From: Thomas Callaway
Sent: 02 January 2015 14:44
To: Planning.Responses
Subject: RE: Planning Consultation on: LU/328/14/PL

APPLICATION LU/328/14/PL

Site Address: Unit 10 Martello Enterprise Centre Courtwick Lane Wick
Littlehampton BN17 7PA

Description of Works: Construction of side extension to industrial unit

Proposed Extension for RJH Construction
Unit 10 Martello Business Centre, Courtwick Lane, Littlehampton
- AS EXISTING + Proposed Roof Plan

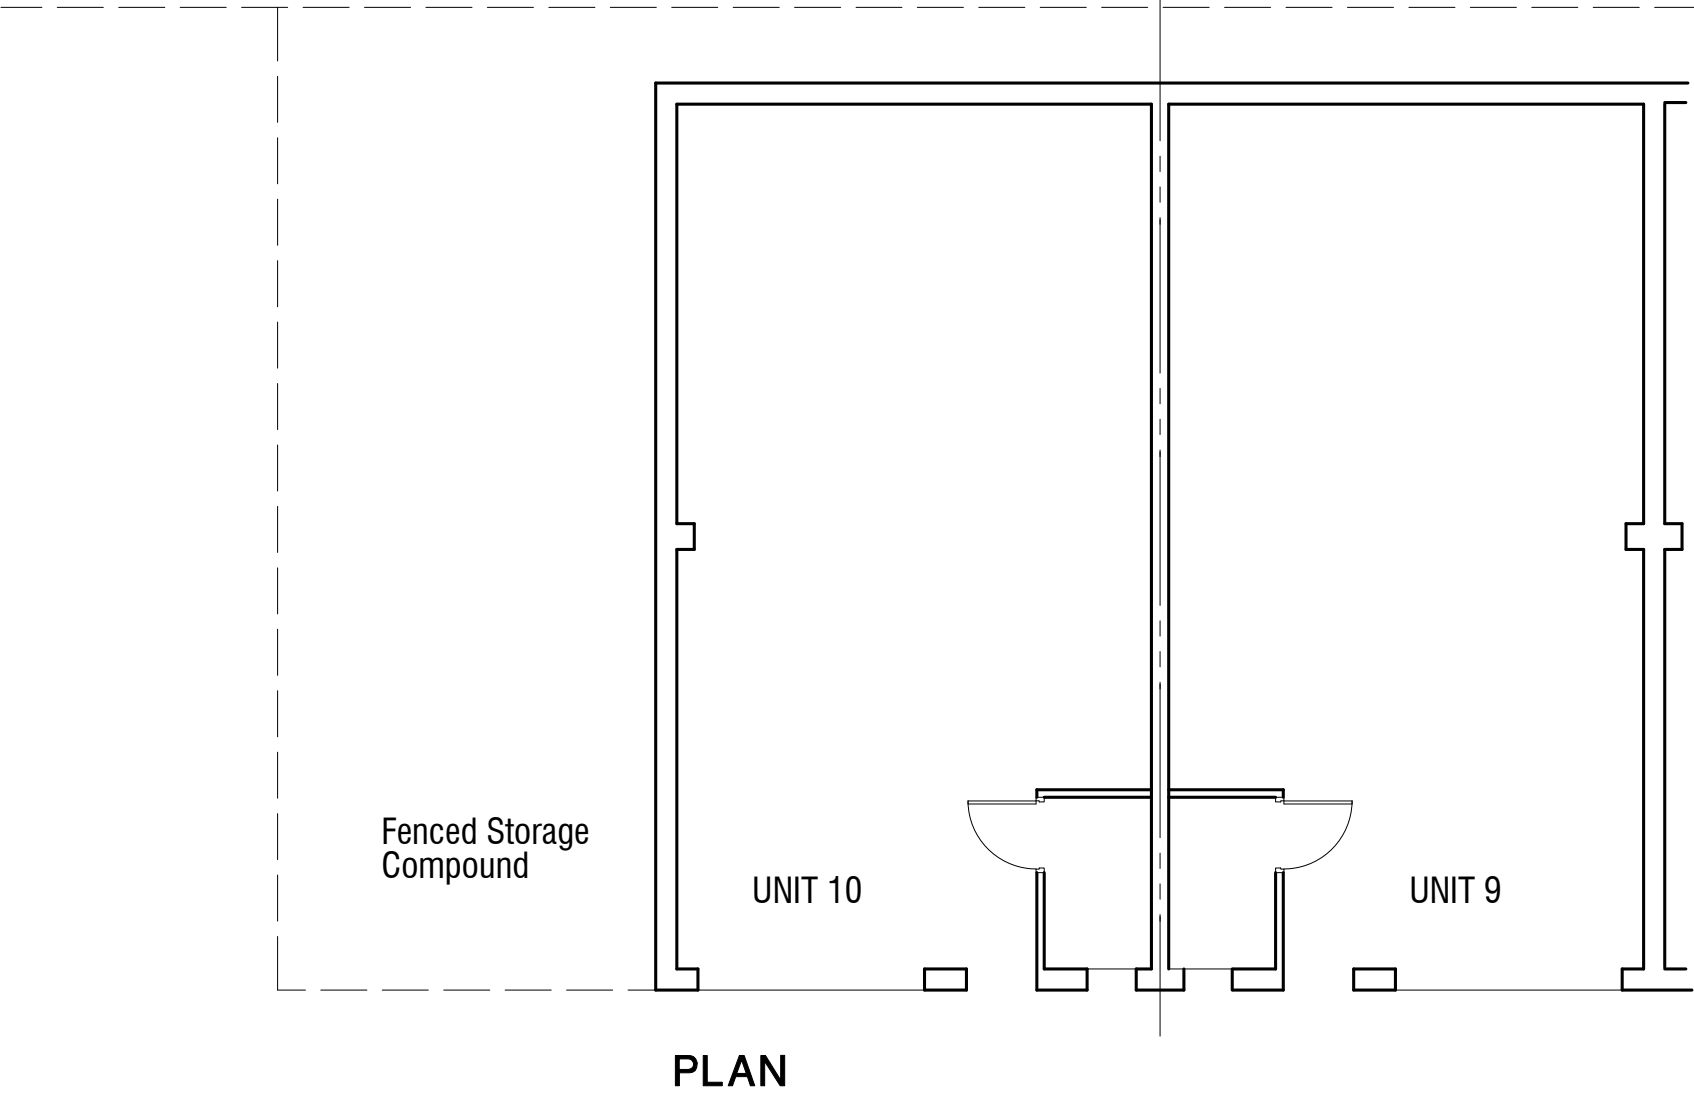
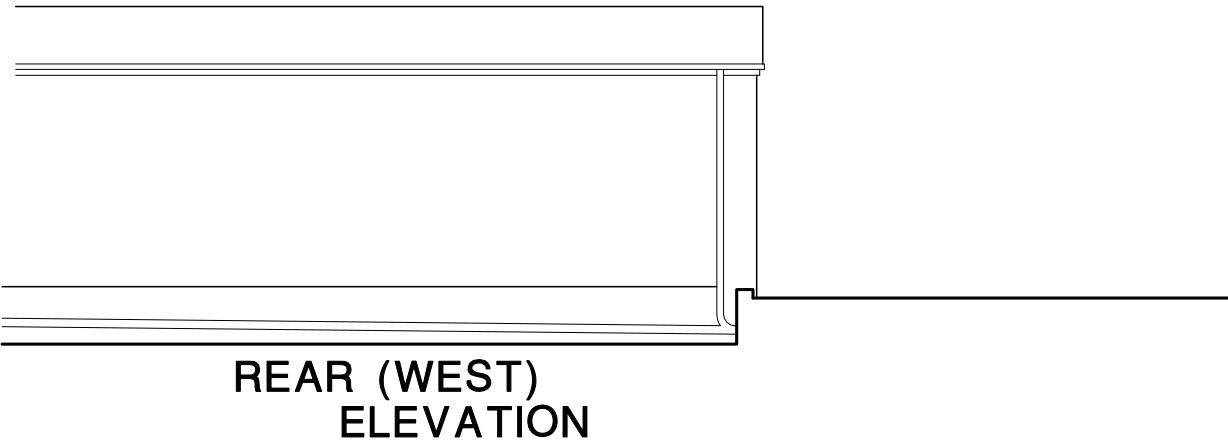
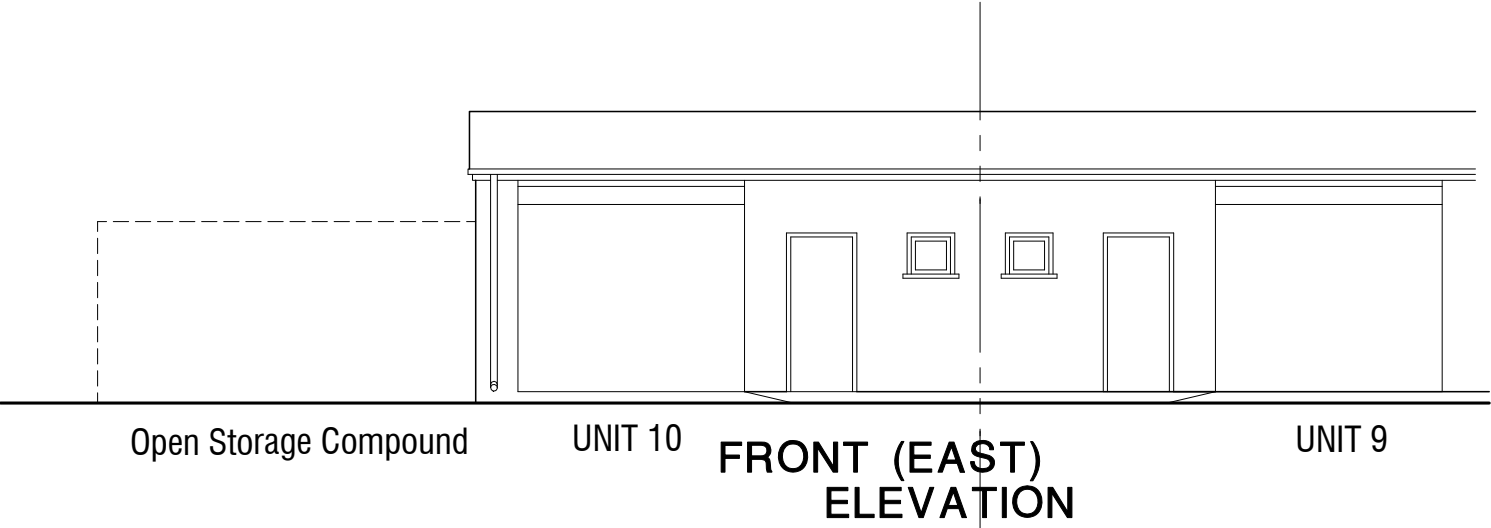
The applicant states that surface water is to be disposed of to the main sewer. Infiltration must be investigated for surface water disposal.

Infiltration rates for soakage structures are to be based on percolation tests undertaken in the winter period and at the location and depth of the proposed structures. The percolation tests must be carried out in accordance with BRE 365, CIRIA R156 or a similar approved method and cater for the 1 in 10 year storm between the invert of the entry pipe to the soakaway, and the base of the structure. It must also have the provision to ensure that there is capacity in the system to contain below ground level the 1 in 100 year storm event plus 30% on stored volumes, as an allowance for climate change. Adequate freeboard must be provided between the base of the soakaway structure and the highest recorded annual groundwater level identified in that location.

Any SuDS or soakaway design must include adequate groundwater monitoring data to determine the highest winter groundwater table in support of the design. The applicant is advised to discuss the extent of groundwater monitoring with the Council's Engineers. Supplementary guidance notes are also enclosed for information.
